Recommendation Report for Planning Permission for Works or Extension to a Dwelling

REF NO: Y/79/25/HH

LOCATION: 2 Graham Road
Yapton
BN18 0JT

PROPOSAL: Replacement of garage with single storey detached garage and garden room, replacement rear extension flat roof with monopitched roof, and alterations to fenestration.

Proposed Replacement Garage & House Alterations
at 2 Graham Road, Yapton
for Mr and Mrs J Rolls-Drew
Drawing P01 December 2025 Scale 1:100 @ A3
Proposed Drawing - Floor Plans & Elevations

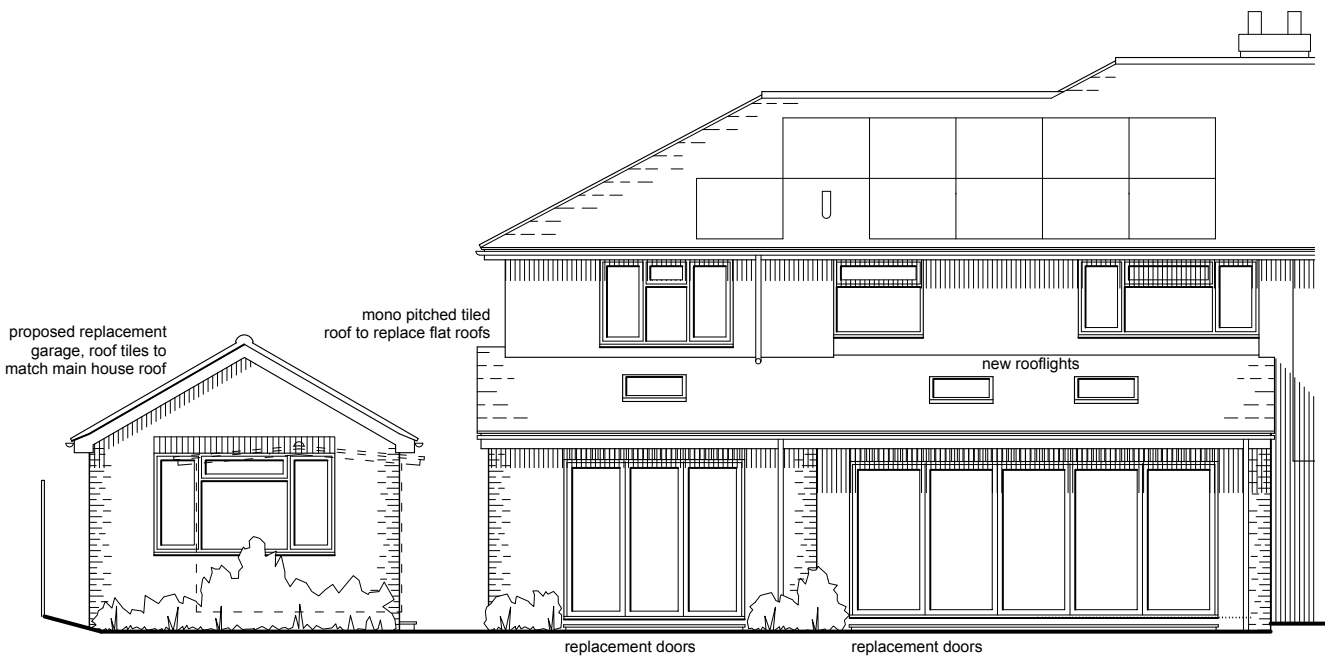
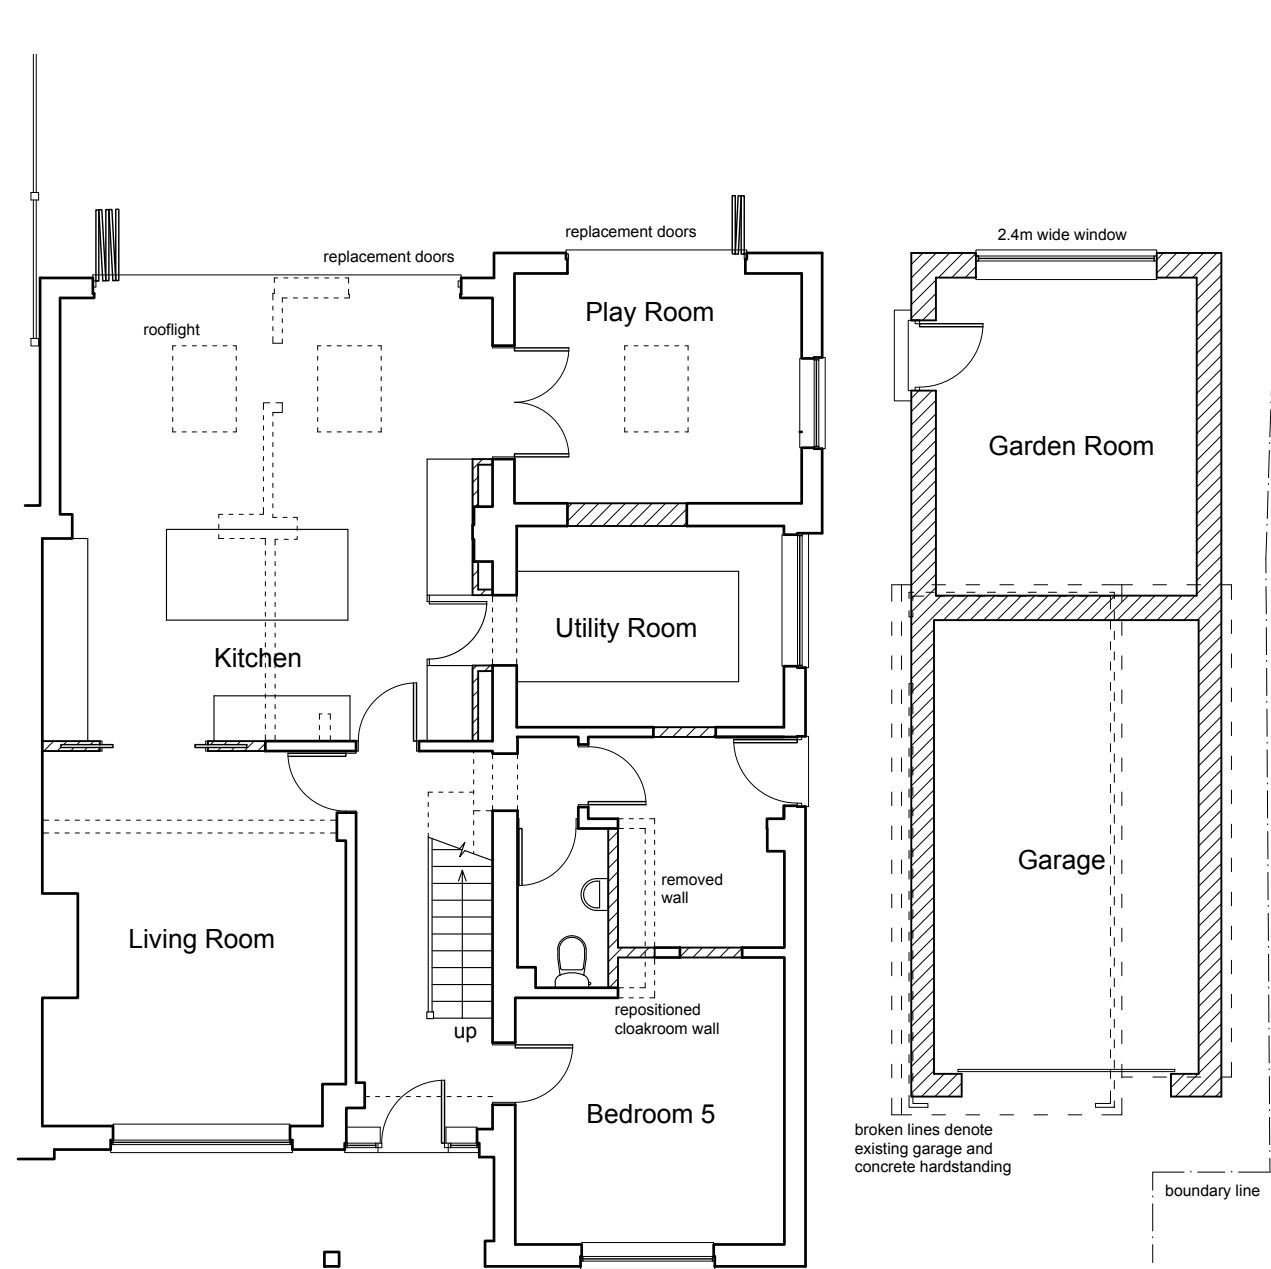
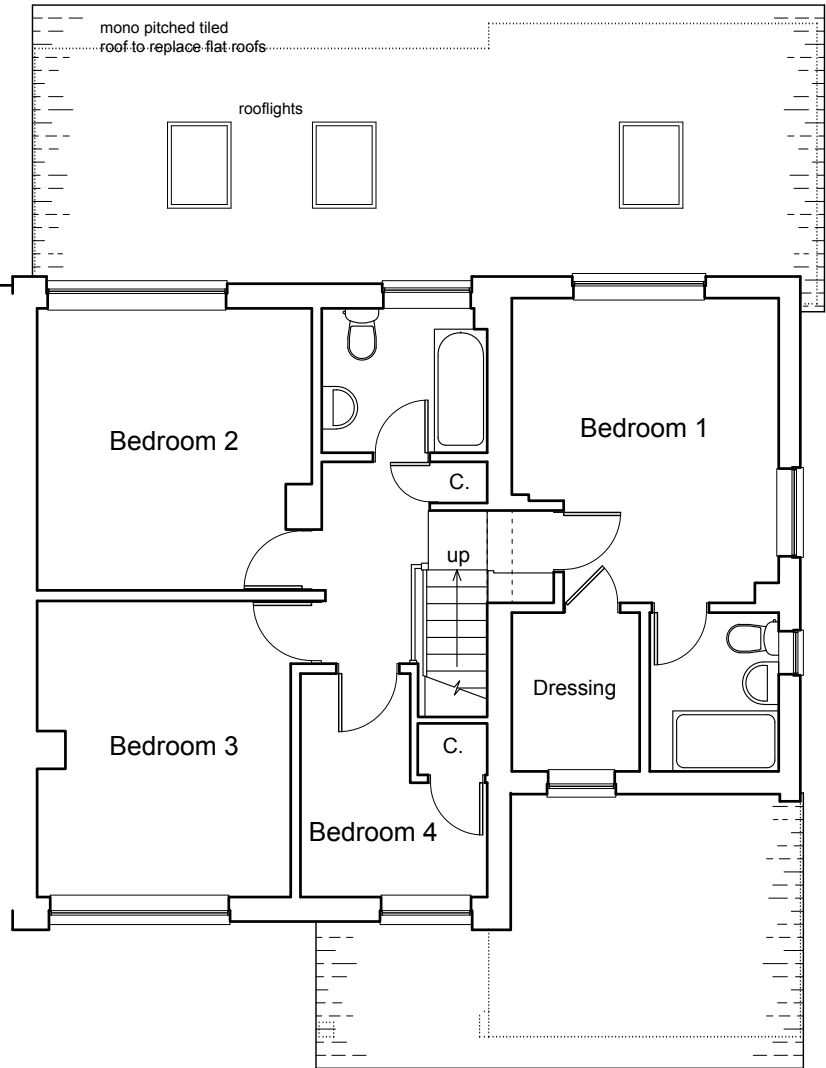
The proposed mono-pitched roof to the existing rear extension would replace the existing flat roof and would be sympathetic to the pitched roof form of the host dwelling. The roof would help to unify the existing rear elevation. As a result, the amended roof form would not appear prominent or out of character, and it would not give rise to any harm to the overall appearance or architectural character of the host property.

Within the replacement roof, three rooflights are proposed, as well as replacement rear doors within the existing extension. The rooflights would be proportionate in scale and would not result in any harm in this regard. The rear doors would replace existing doors and are acceptable.

The proposed replacement roof to the rear extension would be sited to the rear of the dwelling. While it would minimally increase the bulk and massing of the roof within close proximity to the northern neighbour, the eaves height of the extension would remain low level, and the proposed replacement roof

would not result in significant overshadowing or overbearing impacts to the neighbour to the north.

There is additional fenestration proposed to the rear elevation which will provide outlook onto the rear garden of the host dwelling, and rooflights would be high level serving the ground floor accommodation. As such, the proposed fenestration would not result in any additional overlooking of neighbouring properties.

Proposed Replacement Garage & House Alterations
at 2 Graham Road, Yapton
for Mr and Mrs J Rolls-Drew
Drawing P02 December 2025 Scale 1:100 @ A3
Proposed Drawing - Garage & House Elevations

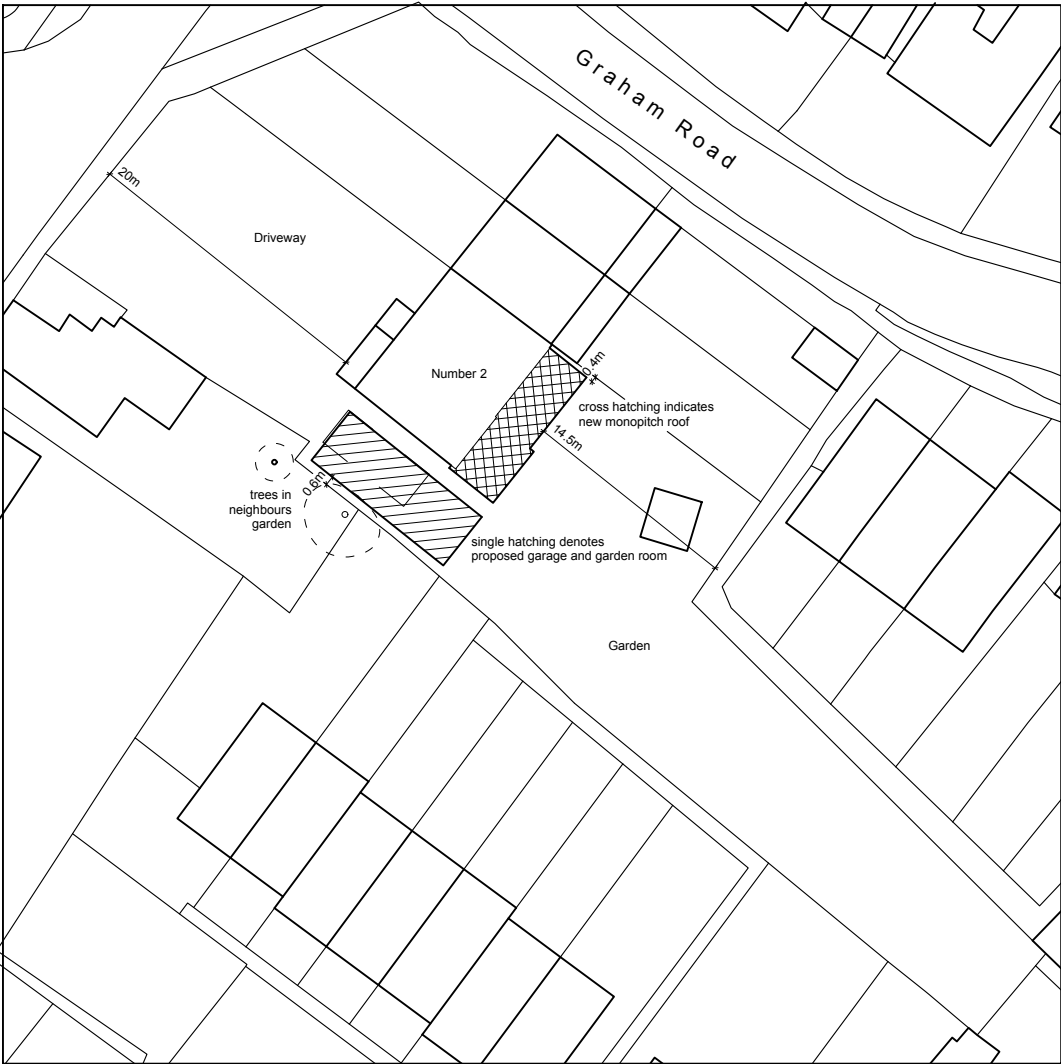
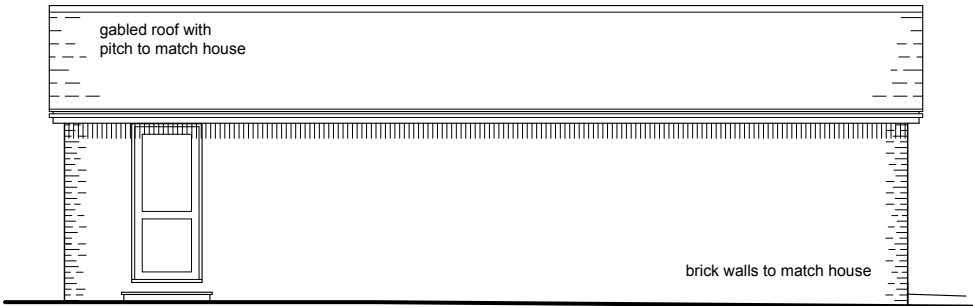
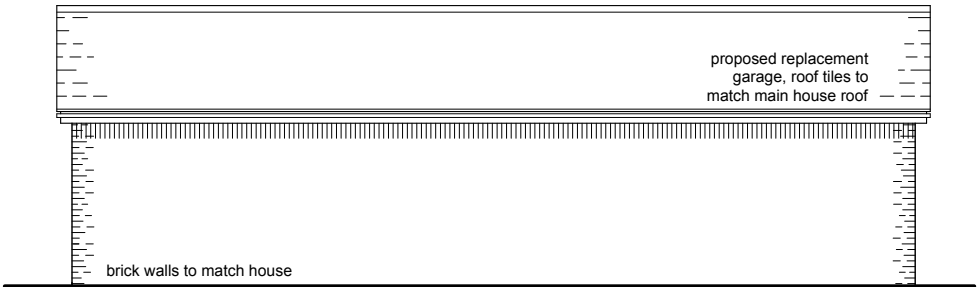
The proposed single storey detached garage and garden room would measure approximately 4.1m in width, 11.1m in depth, with an eaves height of 2.4m and a pitched roof reaching a maximum height of 3.8m. The outbuilding would not project any further forward than the existing detached garage, which is to be demolished. The increase in footprint is primarily to the rear and would not detract from the visual amenity of the host dwelling or the wider street scene. The garage would incorporate a pitched roof matching the pitch of the host dwelling and would be constructed using matching materials, ensuring it reads as a subservient, ancillary addition that integrates well with the main property.

The proposed garage and garden room would be set in approximately 0.6m from the southern side boundary and would abut the rear gardens of neighbouring properties. Given its single storey height and separation from the rear elevations of neighbouring properties, the outbuilding would not result in any overbearing or overshadowing impacts. The fenestration proposed within the garage and garden room would be at ground floor level only, with openings facing towards the application site's frontage and rear. As such, the proposal would not give rise to any overlooking of neighbouring properties.
